Application Reference: WA/108/24/PL Site Name: Stoneybrook Farm Eastergate Lane Walberton BN18 0BA			Initial Issue Date: 27/03/2025 Issue Date: 27/06/2025 Reviewer Reference: ADC/SB & PC		
Summary and Recommendation:					
Objection					
Objection comments in bold , remaining comments to be addressed via condition.					
Please note: Any DOC application should only have a maximum of two consultation responses. If this is the second response for an open application and there are still comments outstanding, then please object to the application.					
	ADC Drainage Comments	Designer Response	ADC Drainage Comments	Designer Response	
Date:	27/03/2025	31/03/25	27/06/2025	22/07/25	
Condition Number: WA/108/24/PL

Project
**Land at Stoney Brook Farm,
Walberton**

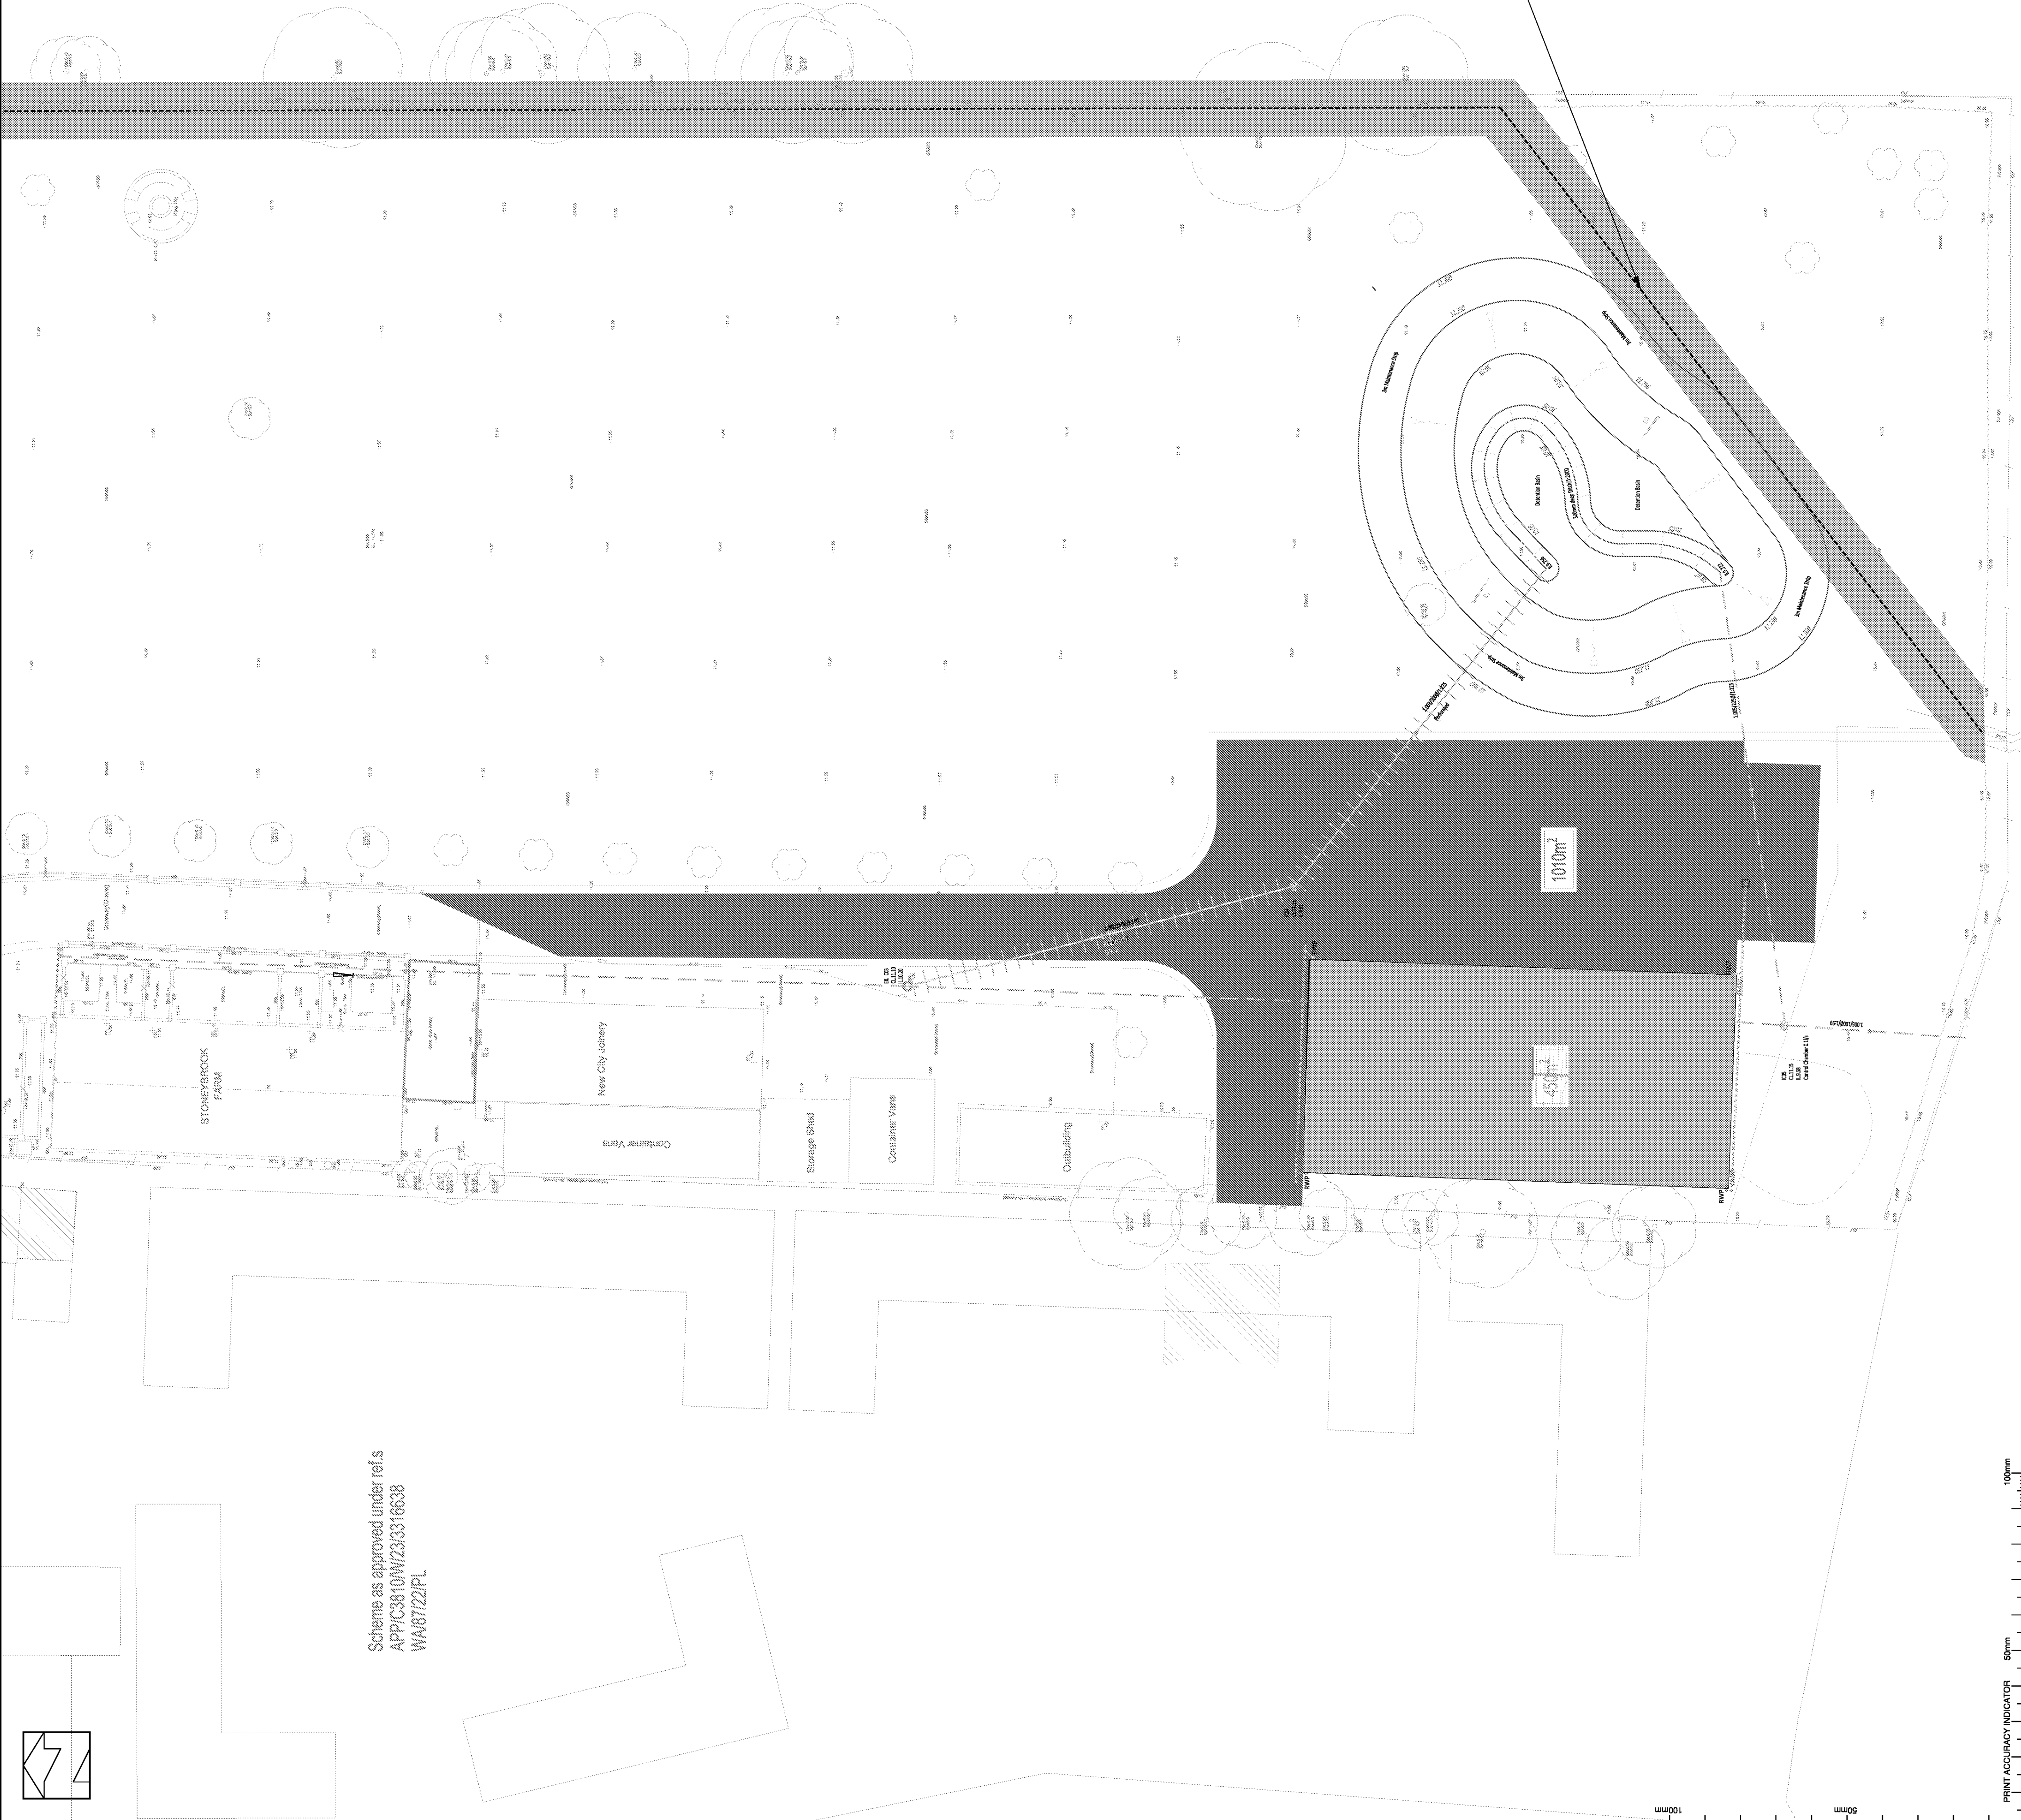
Comment Number					
1.	Please clarify the true bed level, top of bank level and existing connection level to the watercourse.	The bank level is 10.49m The inlet invert level set 1.102m below bank level = 9.388m Watercourse level set 9.350m	<p>This does not achieve the best practice minimum 150mm freeboard required between ditch bed and pipe invert (38mm being achieved). This requirement is stated in our previous consultation response. The layout plan should be updated to clearly show the ditch bed levels/top of bank levels along the entire southern boundary. The existing levels along the length of the watercourse will potentially provide an insight into the true longitudinal profile and may present opportunities to lower the bed levels without compromising gradients and thereby help achieve greater freeboard.</p> <p>Also, it is noted that the existing 100mm diameter pipe outfall which you intend to utilise, passes through the RPZ (root protection zone) of an existing oak tree. This is a potential future/existing issue in terms of root damage to the pipework, thus increase to flood risk. In fact the pipe may already have issues in this respect. It is therefore strongly suggested that a new pipe is installed avoiding any RPZ's. This will help avoid it being questioned during the discharge of any planning conditions.</p>	<p>Following a site visit July '25 and survey of the existing embankment to the watercourse it is confirmed a freeboard of 209mm is provided.</p> <p>The southern boundary to the watercourse is added to the plan. The survey identified the bed gradient to be flat.</p> <p>A CCTV serve of the outfall pipe will be carried out prior the connection of the new system, and should the survey identify tree roots, these will be cleared and the pipelined should it be required.</p>

2.	Please clarify the proposed connection level and demonstrate that a gravity connection can be achieved. This will include pipe gradients and invert levels at nodes.	Existing connection to be retained, proposed to connect into existing chamber by gravity. Hydraulic network calcs attached	<p>See item 1 above.</p> <p>The calculations have not been reviewed as they currently do not take account of criteria as set out in previous comments (ie. items 13,14,15). It is likely that storage will need to be increased once this is taken account of, however, as there is scope within the site to do this, it can be dealt with during the discharge of any planning</p>	<p>Existing levels are shown on the plan, with the Hydraulic network calc attached which also covers the points of 13,14 and 15.</p>

3.	Clarify any land raising that is proposed on the site and demonstrate that this will not increase flood risk.	The Exceedance Plan is attached, Surface Water routes to the existing low spots on the southern boundary.	Please clearly indicate all areas of the site where the ground is to be raised and the level to which it is being raised. This information should be included on the exceedance plan, ensuring that the flow arrows are adjusted if necessary.	The Cut & Fill model shows the areas to be dug and filled across the site. The exceedance flows are shown in considering the level changes across the site.

4.	Clearly show the location and easement for the watercourse on plans.	The watercourse easement is shown.	The easement shown exceeds the required minimum 3m distance from the top of the bank of the watercourse and is therefore deemed acceptable. For clarity, clearly show the watercourse on the layout plan, together with the measured distance from the top of bank to any structure.	The easement is shown for the 15m protection zone for the watercourse. The watercourse location is shown on the plan.
